Application for Legalization of Non-Conforming Dwelling Unit - 15 Longfellow Street1 message

From: Craig Messinger [mailto:crm@portlandmaine.gov]**Sent:** Thursday, December 15, 2016 8:10 AM**To:** Barns, Jennifer <jennifer.barns@tylertech.com>; Matt Sarapas <msarapas@portlandmaine.gov>**Subject:** 15 Longfellow

Unit 2, 2nd Floor

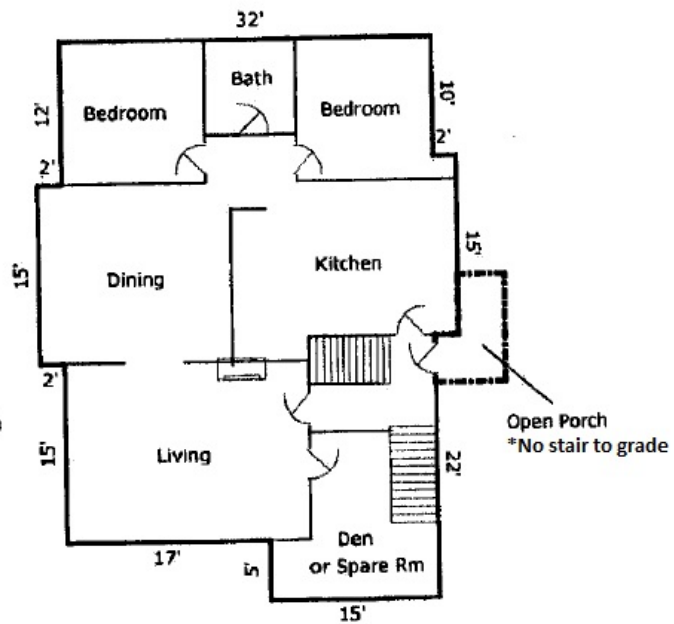
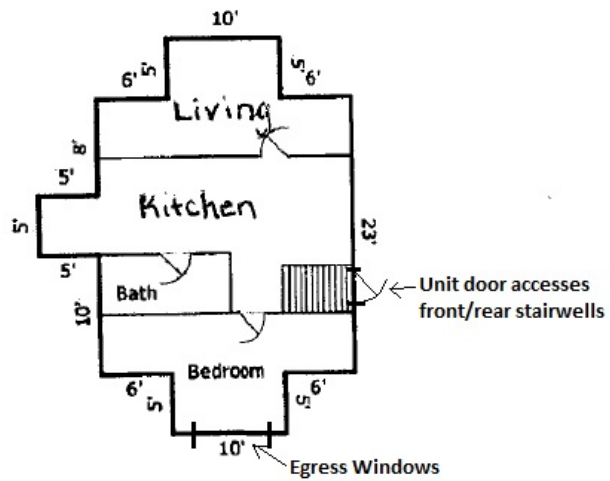
This diagram is not that clear to me. If I documented correctly, at the top of the stairs(2nd floor) you have an option to close off one of the doors going into the second floor unit(you told us that you were choosing to leave those two doors in place, which would have to be rated). Door #4 in your diagram appears to be a door going to the outside of the building, if this is the case, it would not be required to be a rated door. You also had two doors going to your basement level and we gave you the option of removing one of those doors(again, you stated to us that you were choosing to keep both of those doors, in which case they will both need to be rated). Essentially any door that enters/exits into a "common" hallway will be required to be rated. Unfortunately, we do not have the staff to keep revisiting your building, but please feel free to reach out if we can help further,
